SUBMISSION TO WEST SUSSEX COUNTY COUNCIL FOR DEPARTURES FROM STANDARD

Project Name	BEW Parcel SC1 - Form 3
Applicant Organisation	CC Projects, Ashmarden Ltd, Hanbury (PM)
Applicant Ref	BEW Parcel SC1
Highway Authority Ref	ADC Ref BN/11/22/OUT
Applicant Contact Details	Terance McLaughlin Pell Frischmann 07958039622
Date Submitted	17.07.2023 - Rev4

A	Discipline	Road Geometry at proposed Southern Roundabout Junction on existing Lidsey Road
	Type	
B	Relevant Standard(s)	CD116 - Geometric design of roundabouts
	Clause	Section 3.36 - Visibility
C	Difference Between Standard(s) and proposed design	The standards for 70A kph design speed is 120m forward visibility on approach On northbound approach to proposed roundabout 105m is achieved.
D	Reason for Departure (overview)	Land ownership and maintaining visibility splay within either public highway or developer land
E	Associated Project Departures	
F	Other Options Considered	Moving roundabout. This is not considered possible due to land ownership boundaries. The proposed position allows for all accesses to be maintained.

A13394-PF-ZZ-XX-DR-CD-00106 P06

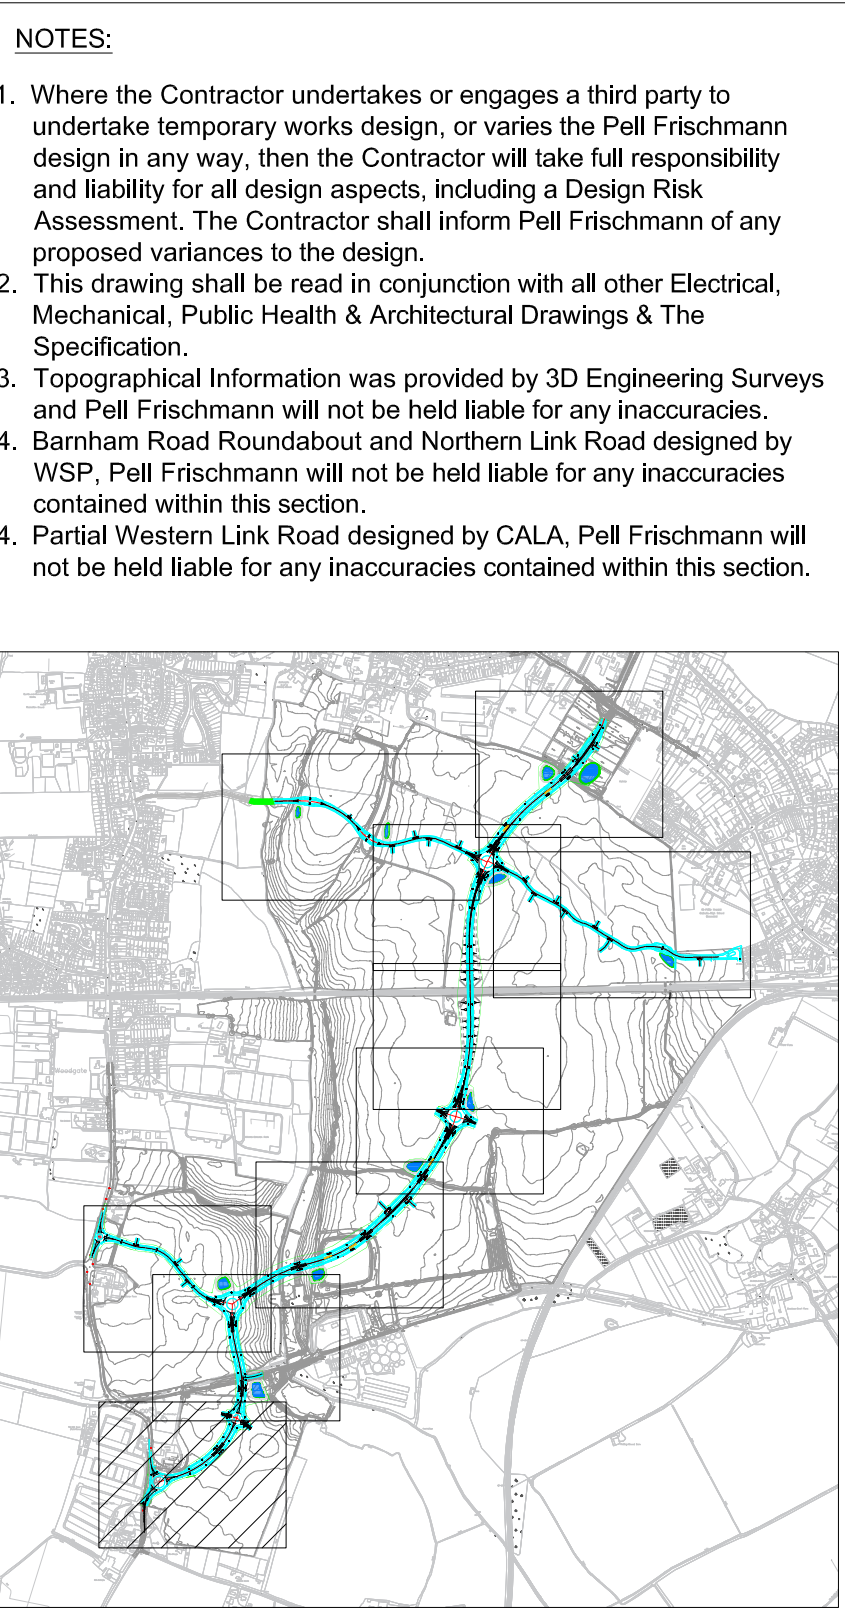
A	Included Measures	Additional signage and red markings proposed to be introduced to reinforce speeds. This is to be developed at Detailed Design Stage
B	Rejected Options	Rumble Strip on approaches to junctions rejected by WSCC under consultation

NAME 1	David Lambert		
ROLE	Lead Professional - Highway Design		
SIGNED		DATE	
NAME 2	Alex Sharkey		
ROLE	Improvements Team Manager		
SIGNED		DATE	
MARK ONE BOX:	1- APPROVED ☐	2-APPROVED WITH COMMENTS ☒	3- REJECTED ☐
COMMENTS	Approved subject to the following: 1) An internally illuminated 'keep left' bollard shall be installed at the southern point of the southern splitter island such that it is visible from a point 120m south of the give way line. 2) A chevron sign to diagram 515 shall be mounted on the roundabout central island in a position such that it is partially visible from a point 100m south of the give way line. 3) Either a pictorial ADS sign showing the form of the roundabout, or roundabout warning sign(s) sized and sited in accordance with Traffic Signs Manual Ch 4, shall be sited on the northbound approach to the roundabout such that it is viewable from a point at least 120m south of the give way line. If a warning sign is used consideration may also be given to the use of an accompanying 'SLOW' marking. If an ADS is used a warning sign will not be required unless it is deemed to be necessary through the road safety audit process.
